PLANNING CONSULTATION RESPONSE

| Application No | 2026/0244 |
| Proposal | Demolition of existing building and septic tank and erection of new single storey community and sports pavilion, reconfiguration of parking, new landscaping and other associated works. |
| Consultee | Highways Development Control |

Drawn By: OHJ	Date: 29.01.2026	
Checked: SD	Scale: 1:500	Paper: A3
Drawing No. AMA-300601-ATR-001 1.3	Rev. P03

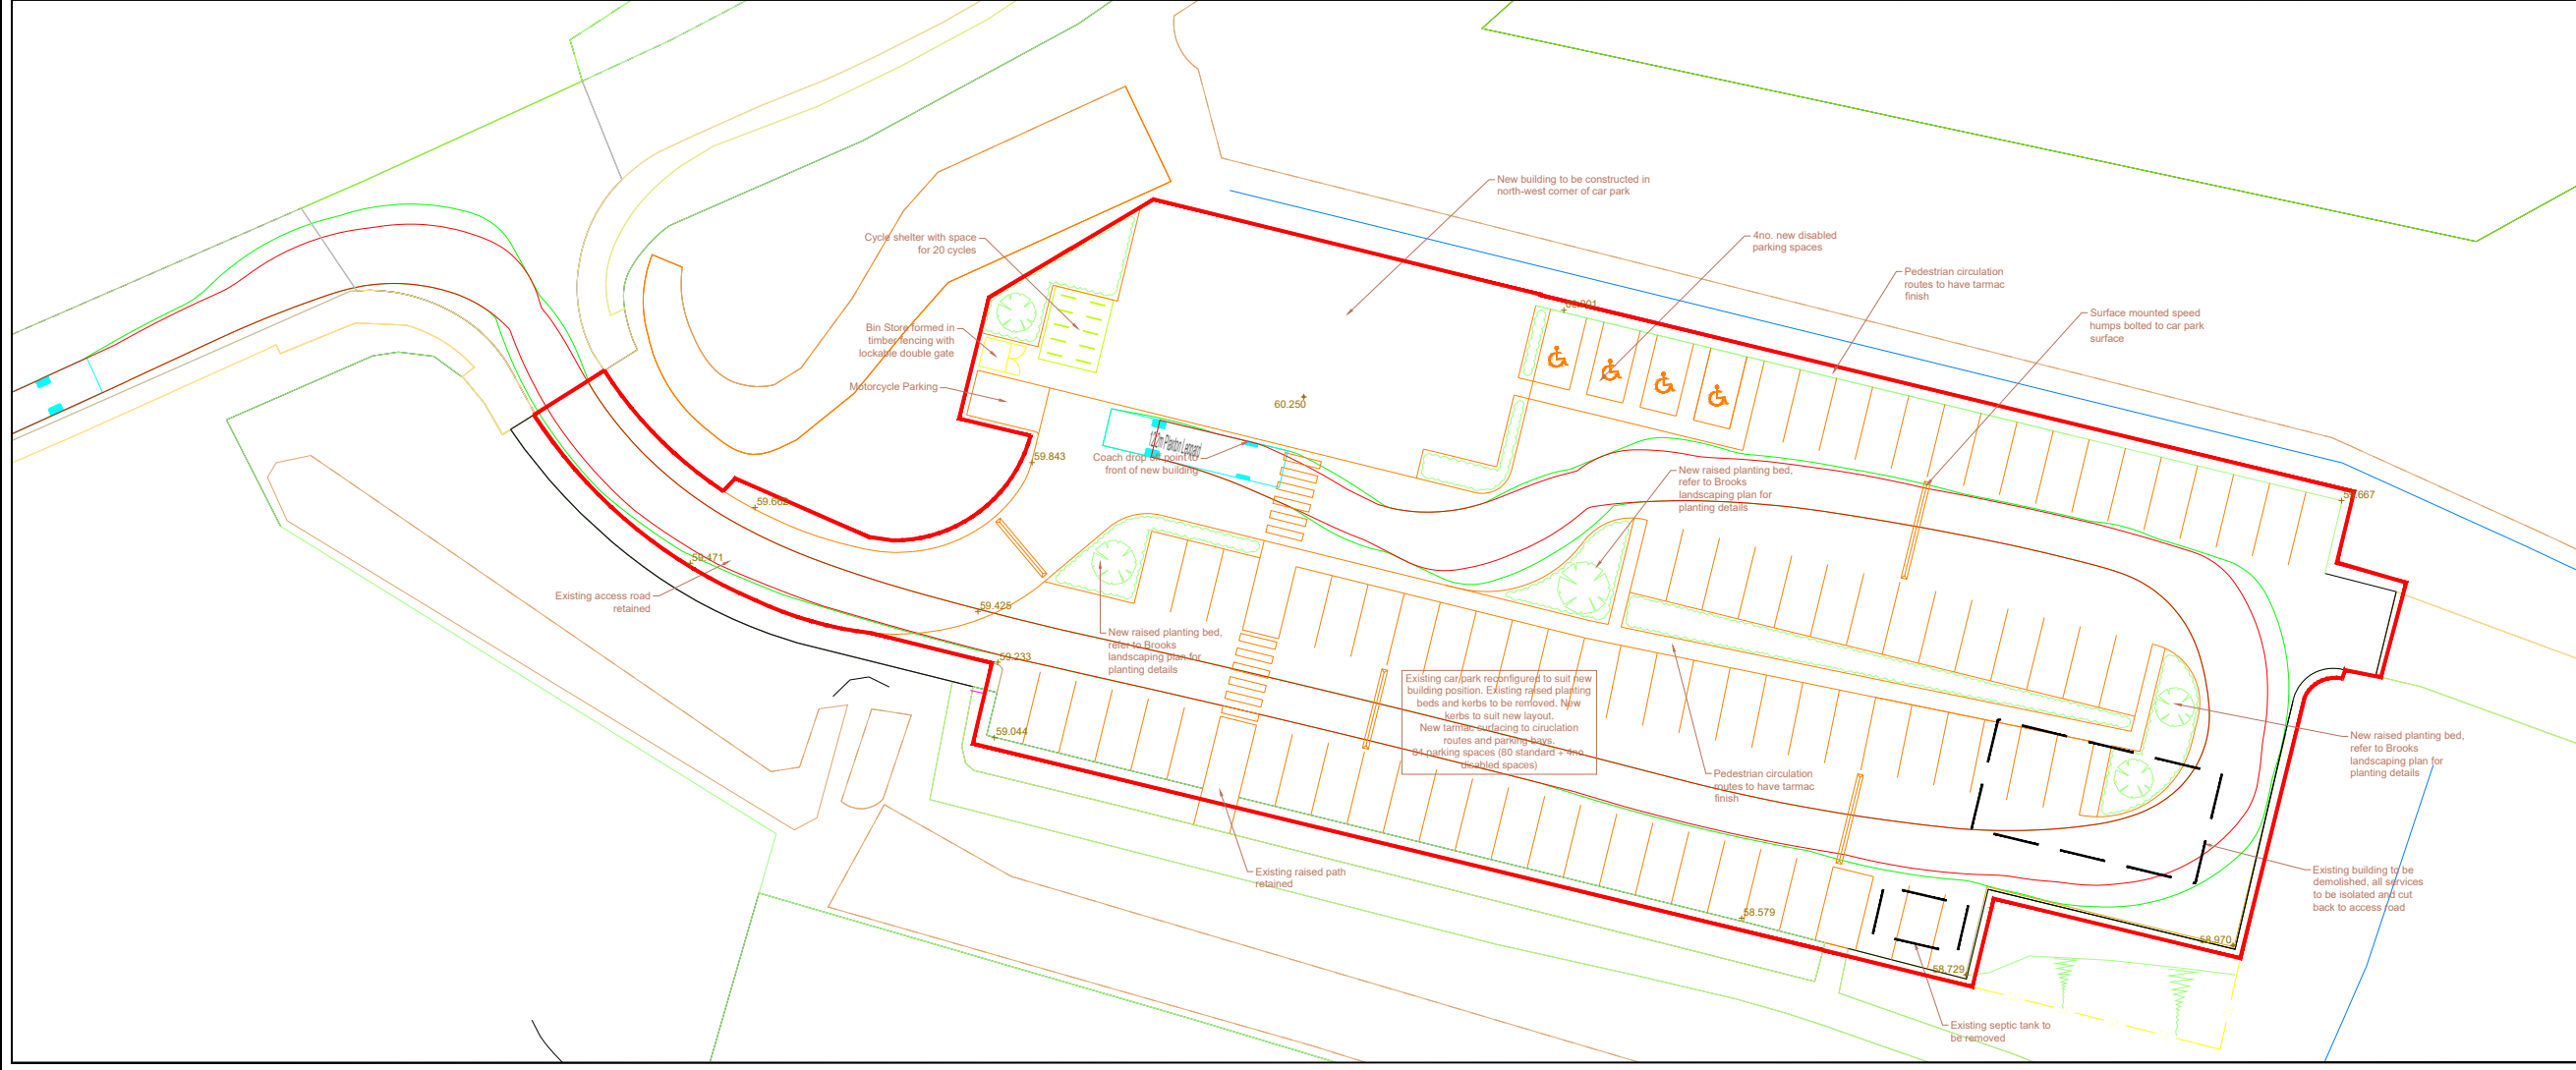
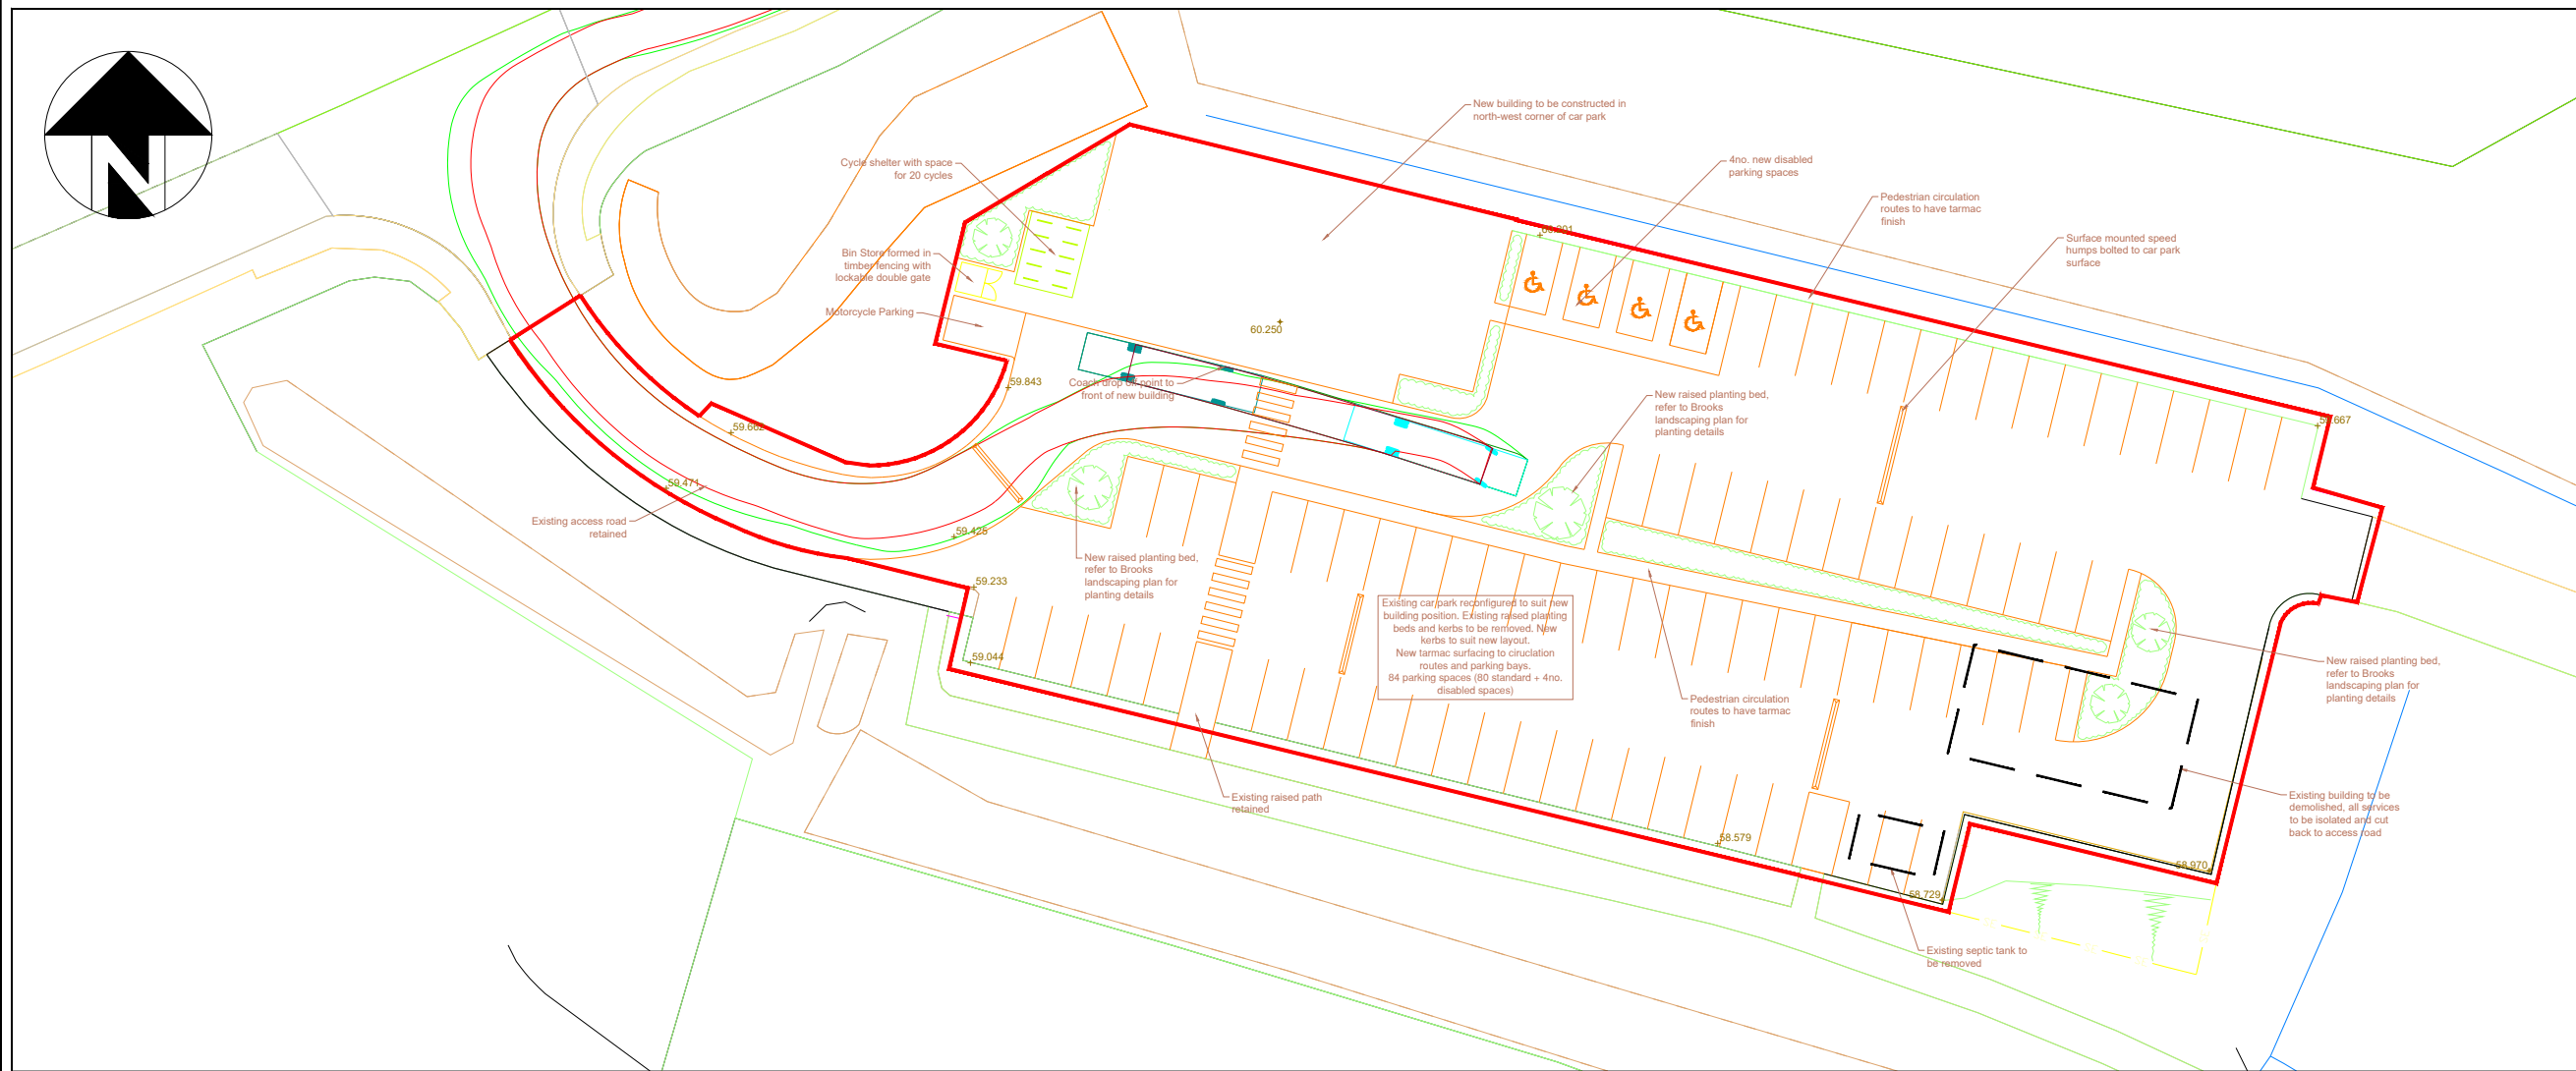
The proposed arrangement requiring coaches to enter the site and reverse to the drop-off area, crossing a pedestrian route, requires careful consideration from a general safety perspective. While the manoeuvre is not anticipated to result in a material impact on the operation of the adopted public highway, it would introduce reduced driver visibility and an increased potential for conflict between vehicles and pedestrians within the site.

In this regard, it would be preferable for the location of the coach drop-off area to be set as far from the pedestrian crossing point as reasonably practicable in order to improve intervisibility between pedestrians and drivers, particularly for pedestrians emerging from behind a stationary coach. The use of clear 'carriageway and footway' markings, together with high-visibility pedestrian crossing markings and signage, would assist in reinforcing awareness and managing interaction between users.

Swept path analysis for a 12.2m coach raises concerns. The optimum path shown on plan ref AMA-300601-ATR-001 1.3 Rev P03 shows minimal offset between the design vehicle and rear of parking spaces / kerb lines and proposed raised planting beds. The paths shown for the coach circulating indicate a minimum 0.5 m clearance to the rear of parking kerb lines and raised planted beds is not maintained. This lack of offset provides insufficient tolerance for drivers not maintaining the optimum path and with tail swing, increases the risk of kerb strikes, damage to planting and infrastructure, and conflict with parked vehicles and pedestrians. As a result, the layout is not evidently suitable for safe and reliable coach manoeuvring under real-world operating conditions. Please amend layout or provide revised tracking for betterment as appropriate.
